44 Pitt Street
Redfern 2016
21st March 2013

RE: Application No MP09_0068

We write to elucidate our concerns regarding number of elements relating to the proposed development at Rachel Forster Hospital.

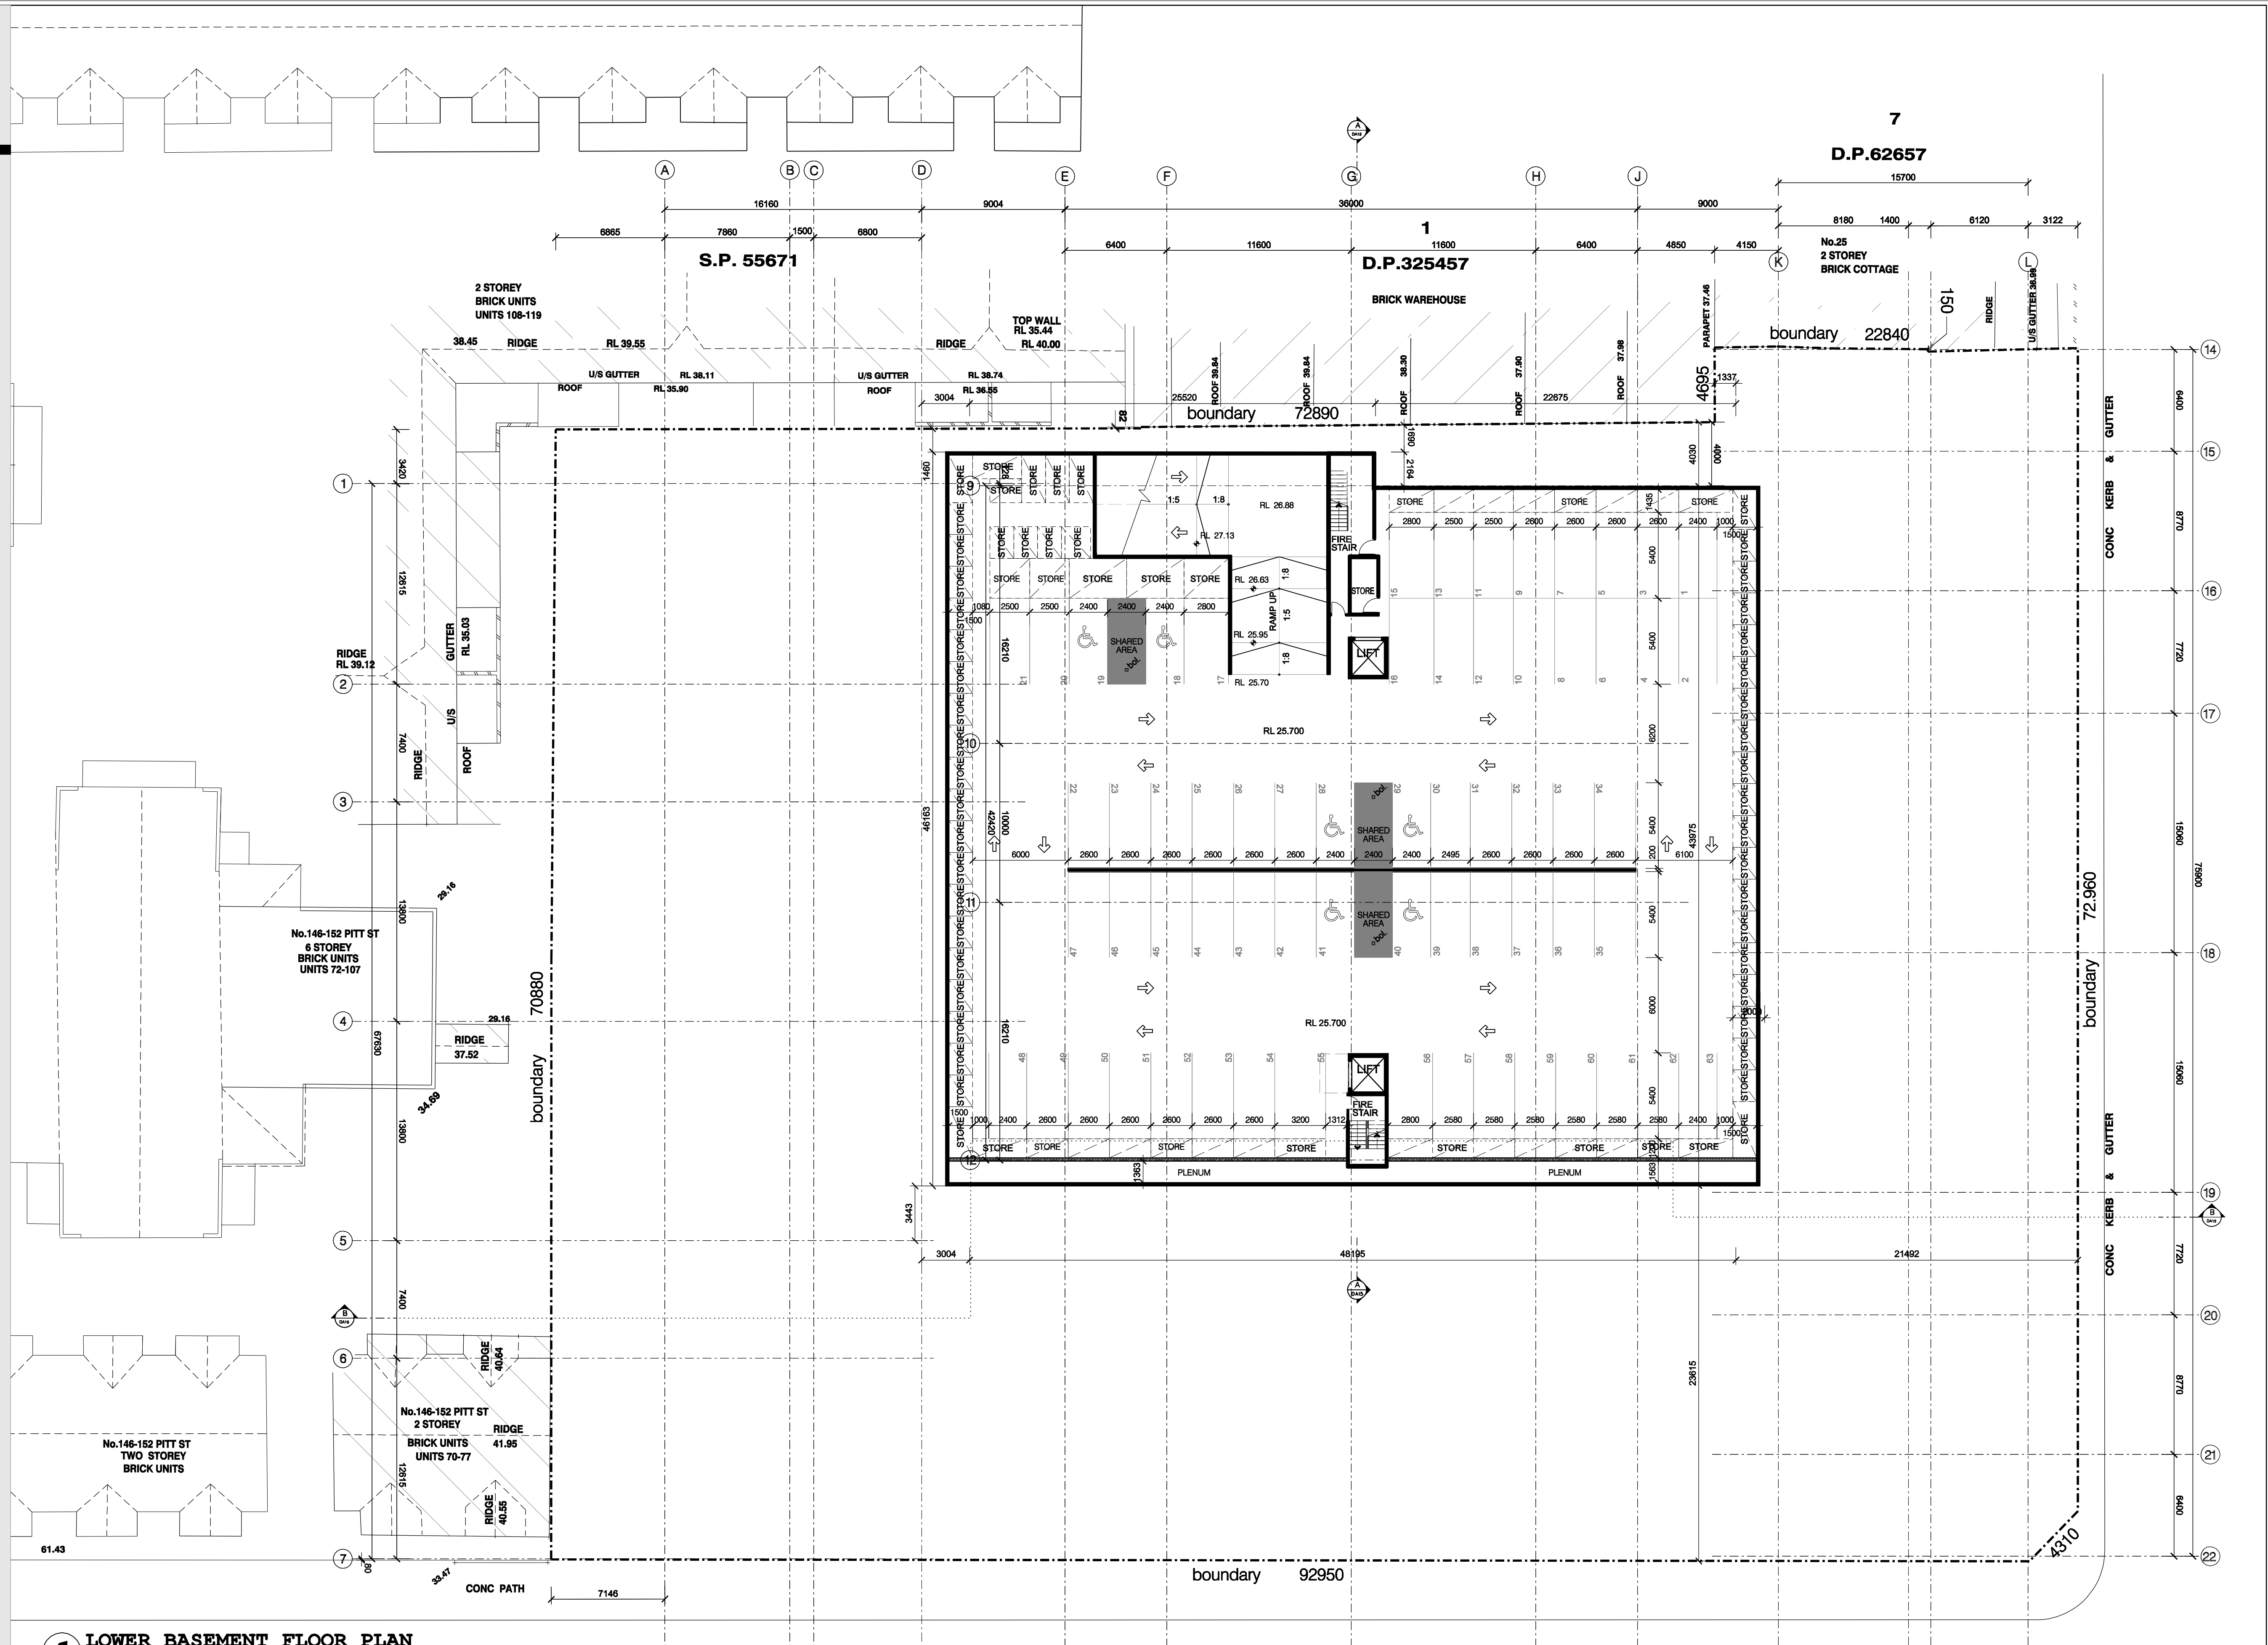
While the plans allow for 170 parking spaces (for 159 apartments) this does not address visitor parking in any real way.
